CITY OF ALBUQUERQUE

December 16, 2024

**Re: Albuquerque Collegiate Charter School
Neighborhood Impact Assessment (L09D032)**
Engineer's Stamp DRAFT-No date
Via [email: jbecker@tierrawestllc.com](mailto:jbecker@tierrawestllc.com)

CONCEPTUAL
TRAFFIC
CIRCULATION
LAYOUT -
CAMPUS PLAN

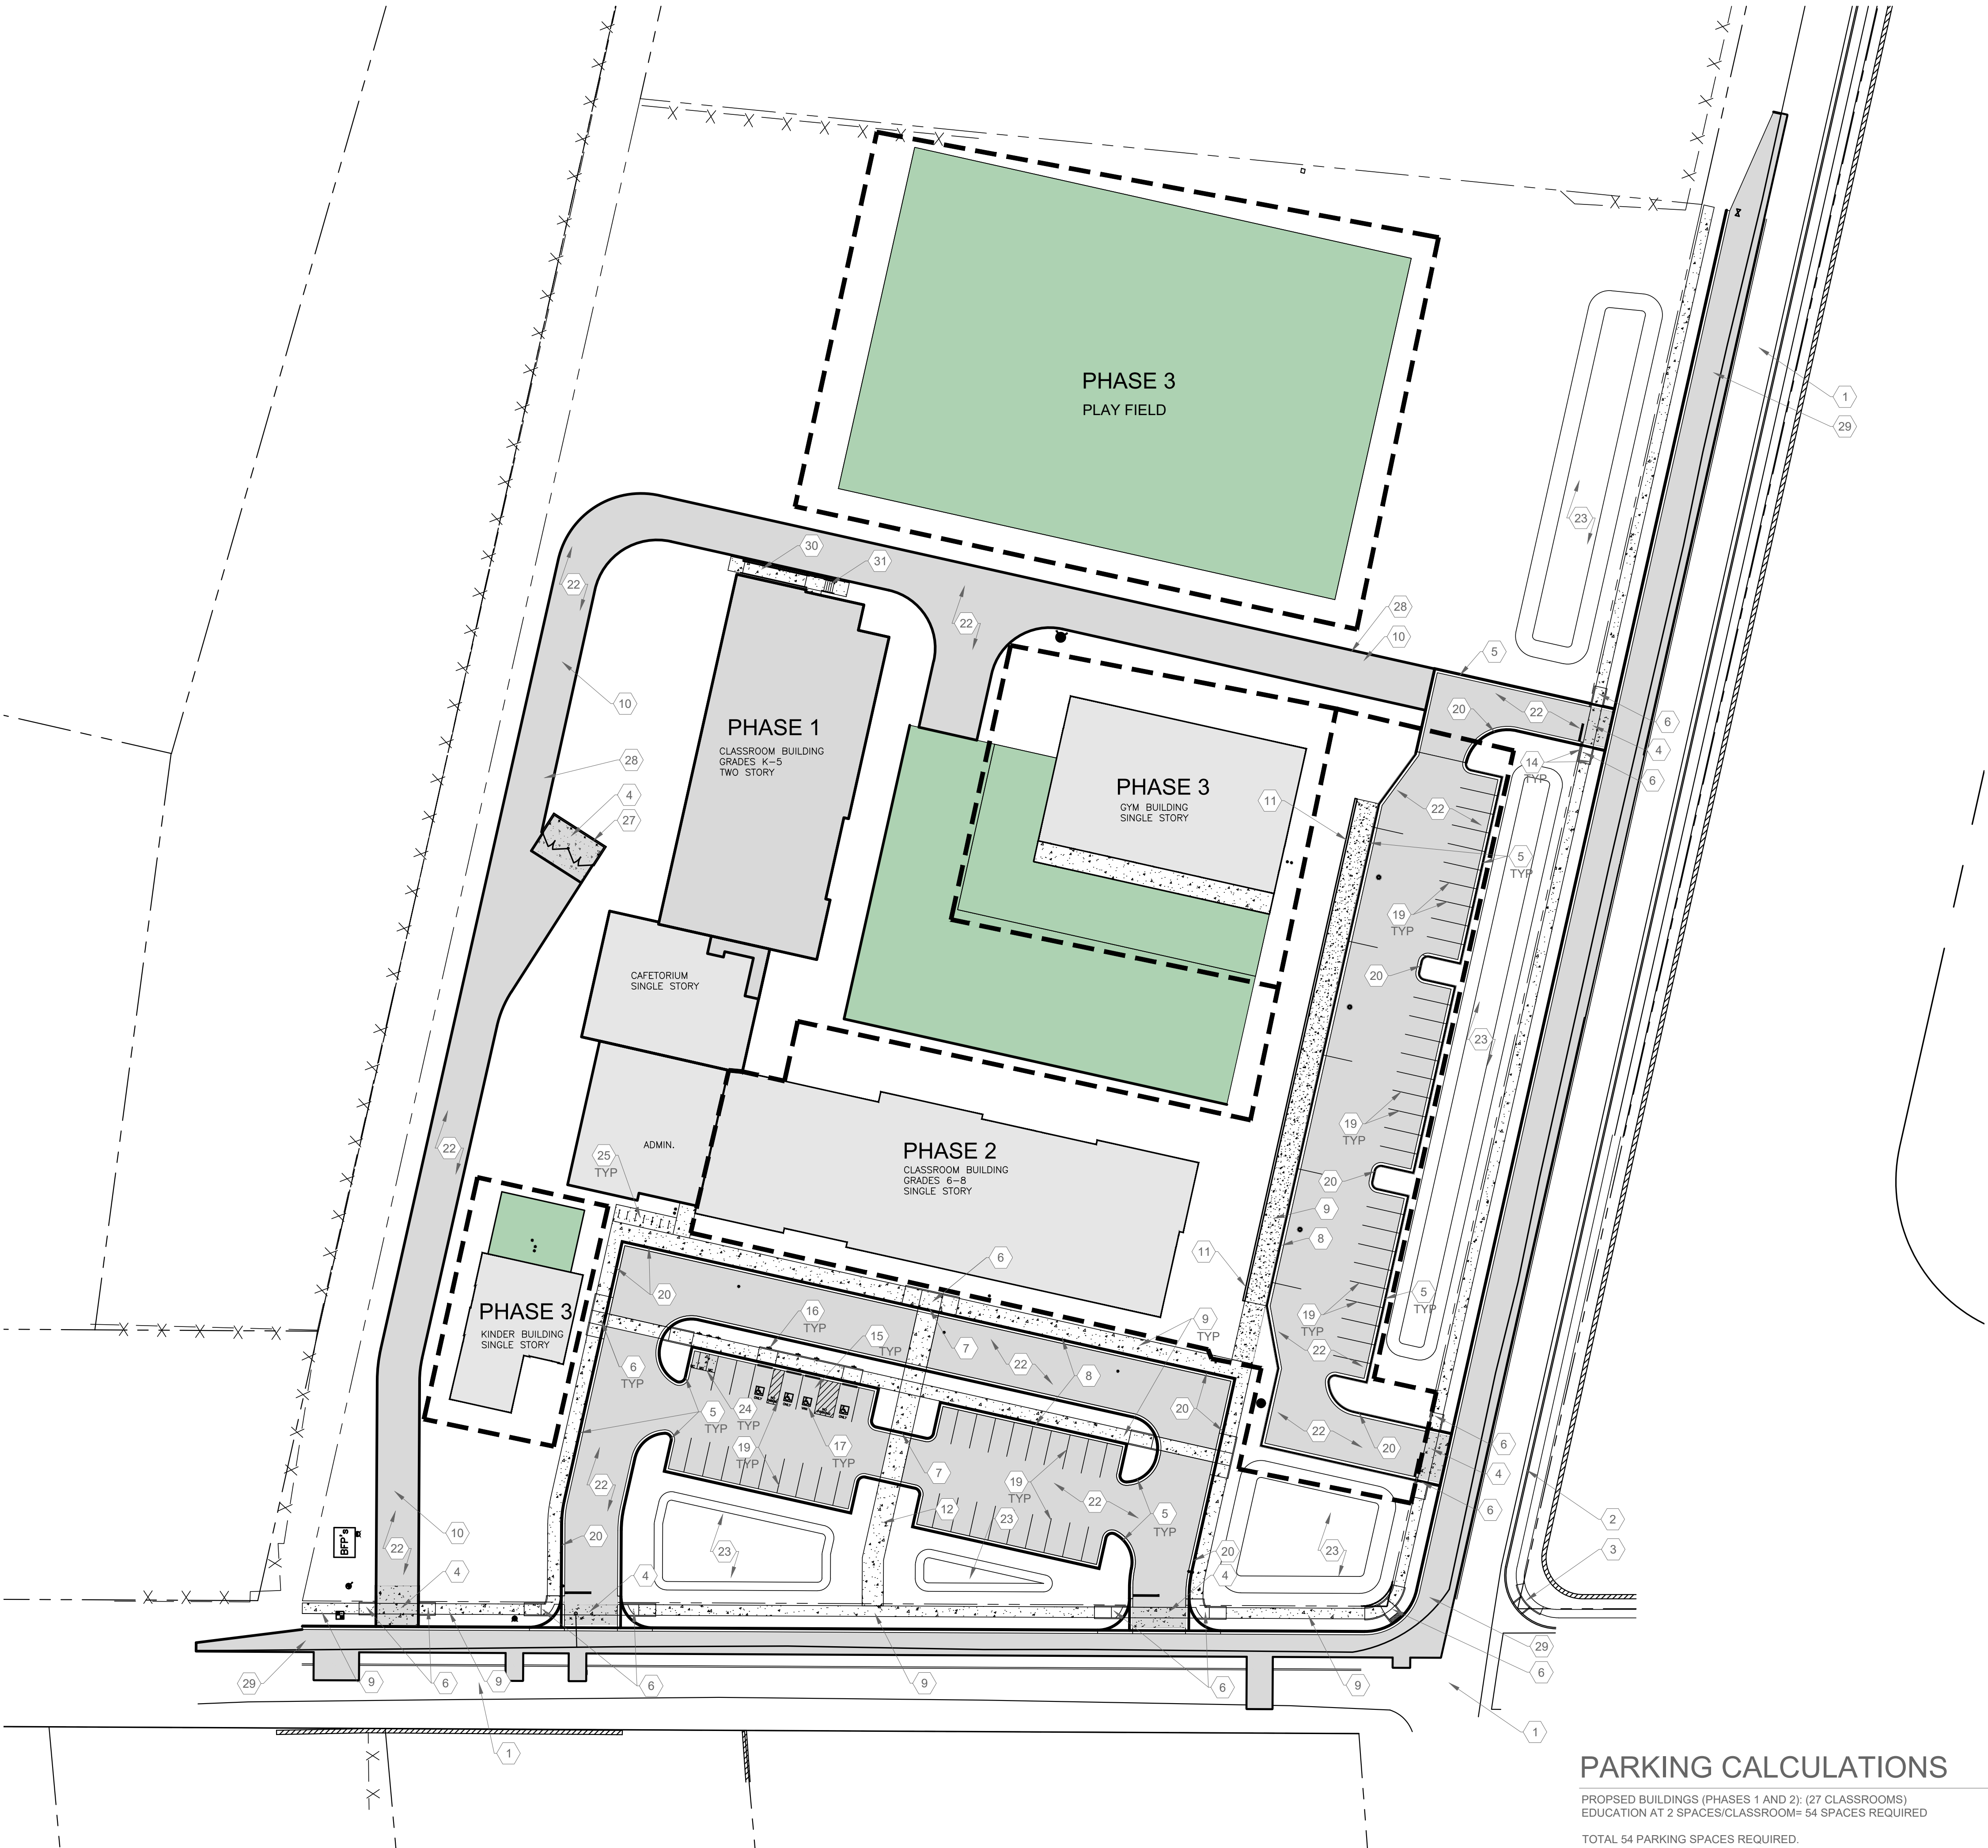
1. Include distances from intersections to driveways and a directional arrow for the south parking lot on the Site Plan. Site plans are not constrained to fit on the 8.5x11 size paper of the Study. Provide a Site Plan minimum size of 11"x17". *Agreed, a larger format drawing with distances between intersections and driveways and directional arrows are included in the report.*

2. Identify the Phase on the Masterplan for the south parking lot. *The south parking area is included in Phase I. This is now identified on the Site Plan.*
